# CITY OF ALBUQUERQUE

**Re: Advanced Auto Parts  
10800 Unser Blvd. NW  
Request for Temporary 30-Day CO – Accepted  
Engineer's Stamp dated: 4-28-16 (A11D012)  
Certification dated: 12-1-16**

CG-101

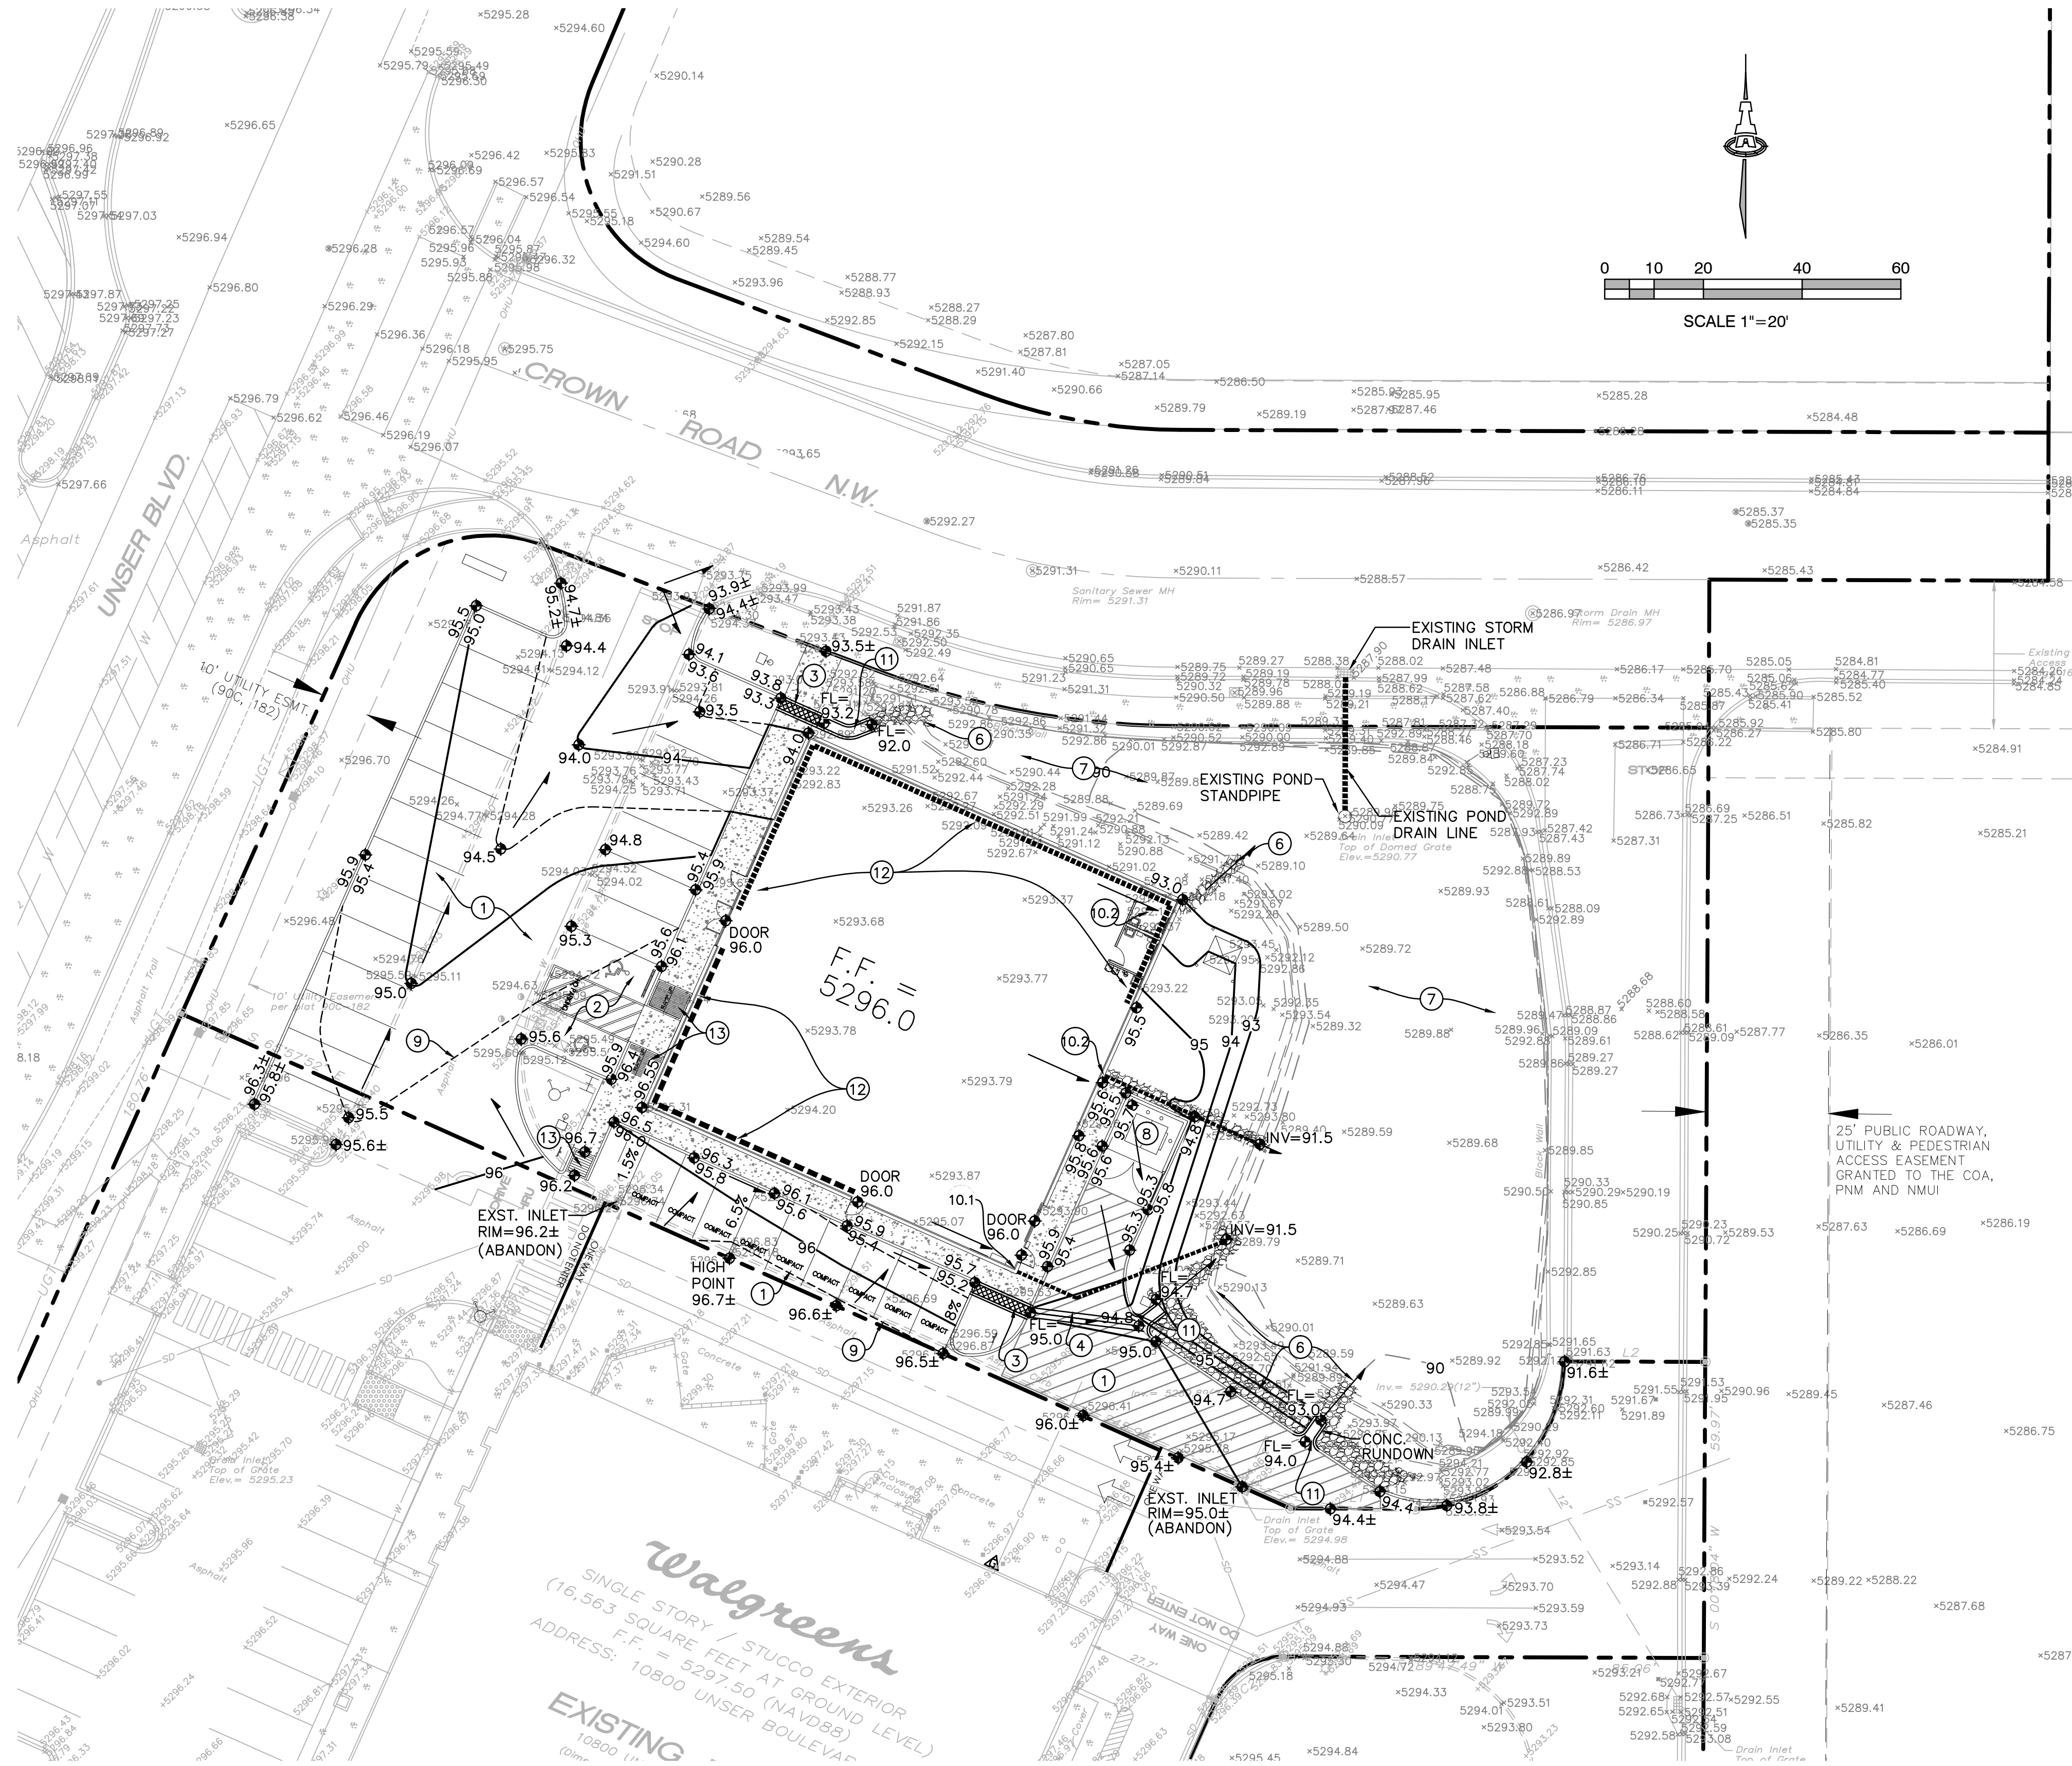
- Both sidewalk culverts were designed as 18". They are both approximately 9". Provide calculations indicating the smaller sidewalk culverts are acceptable.
- The 24" concrete swale note #4 was not constructed. There is a depressed area where the concrete meets the pavement. Indicate on the as-built that this is acceptable.
- The concrete rundown on the NW corner of the building was not constructed and has been replaced with fractured rock. This is acceptable however there will probably be erosion at that point. Indicate on the as-built that this is acceptable.
